Kirklees Metropolitan Borough Council
Development Management

Our ref: RA/2025/149072/01-L01
Your ref: 2025/90673

Erection of detached warehouse

Adj, 7, Halifax Road, Millbridge, Liversedge, WF15 6JQ

7 Halifax Road, Mill Bridge, Liversedge
Development Proposals

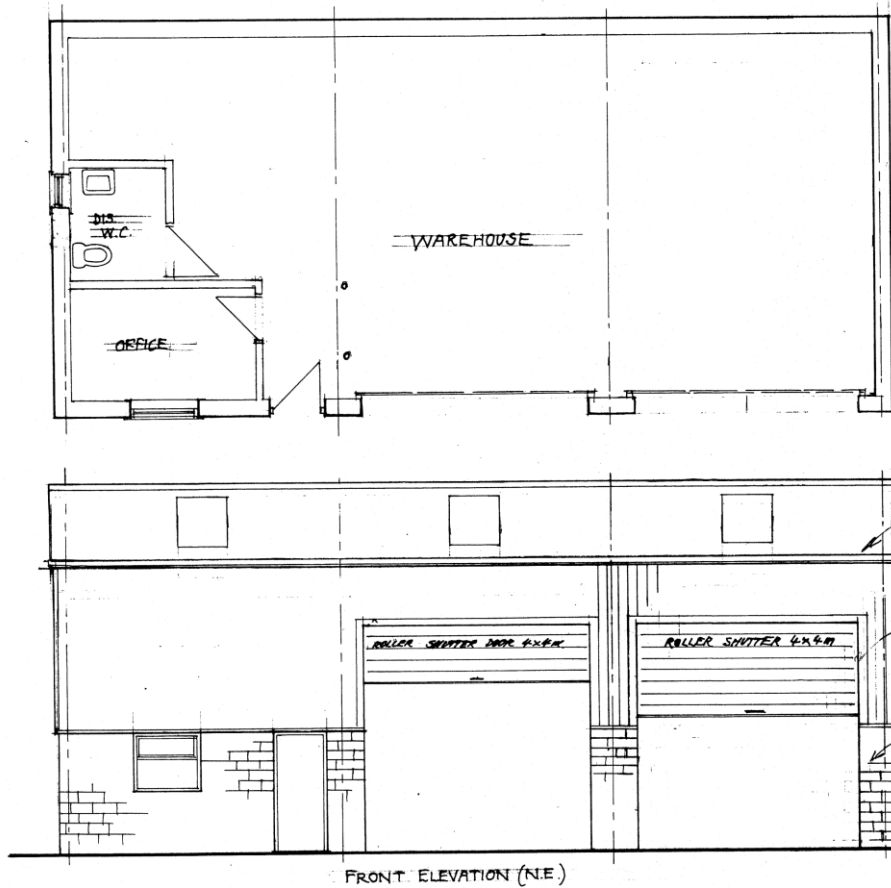
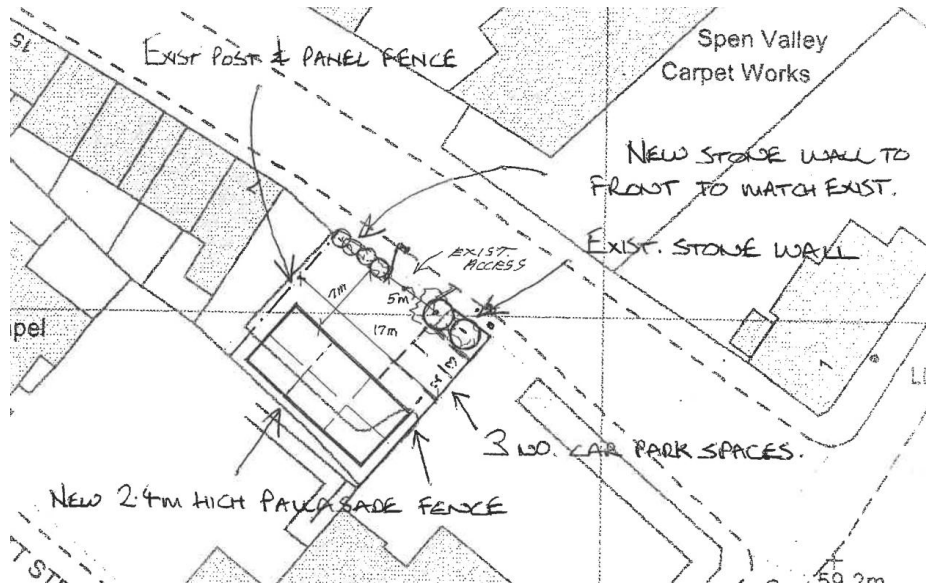
Additionally, we note the proposed building is positioned above a culverted ordinary watercourse.

Additionally, the applicant will need to demonstrate that their development will not comprise the structure of the culvert or prevent access for maintenance.

We recommend an easement of 8m or 45 degrees from the outer edge of the base of the culvert running under the site. Flood mitigation around culverts should consider what would happen if the culvert collapses.

Where possible, culverted watercourses should be opened up as part of development proposals. Consideration should also be given to the maintenance of the culvert. Because this is an ordinary watercourse, the LPA / Lead Local Flood Authority will need be satisfied regarding the structural integrity and maintenance of the culvert.
